Application for Planning Permission for Works or Extension to a Dwelling

Development: Internal alterations including loft conversion and associated works together with solar panels.
Location: Copperwick 5 South View East Preston BN16 1PX

First Floor / Roof Plan
1:50

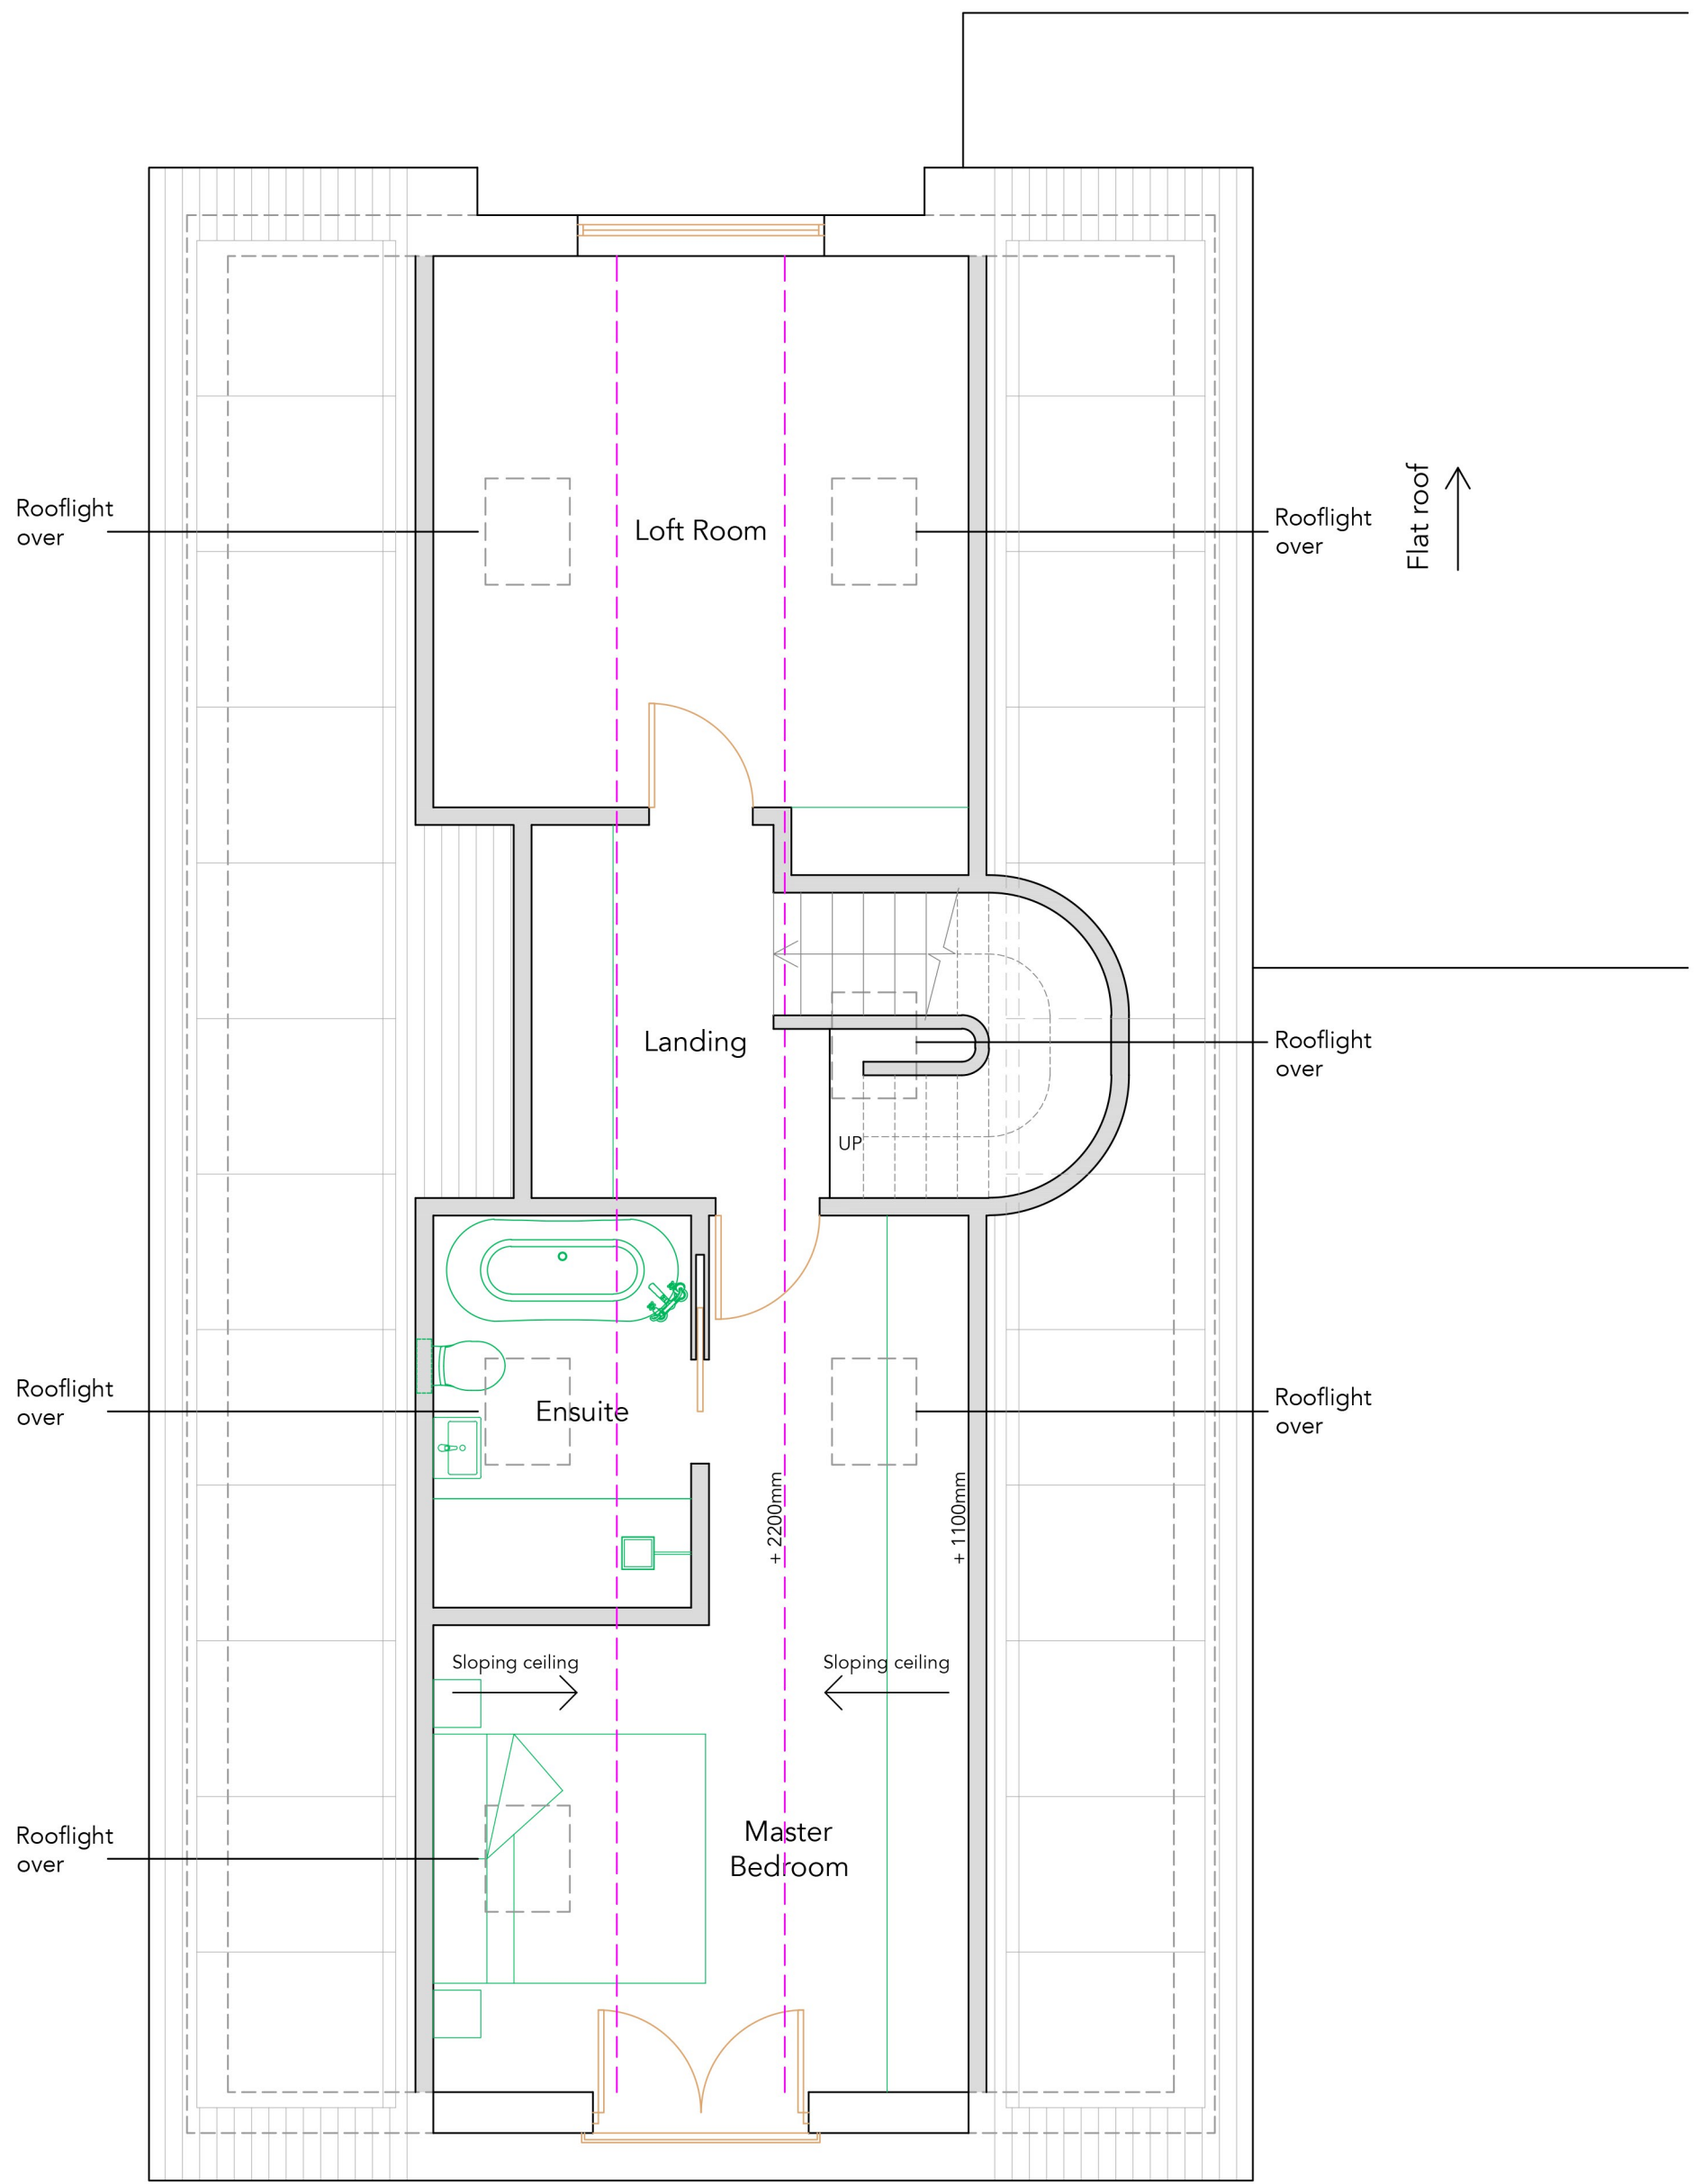
The proposed first floor/roof plan does not show the proposed solar panels in the roof.
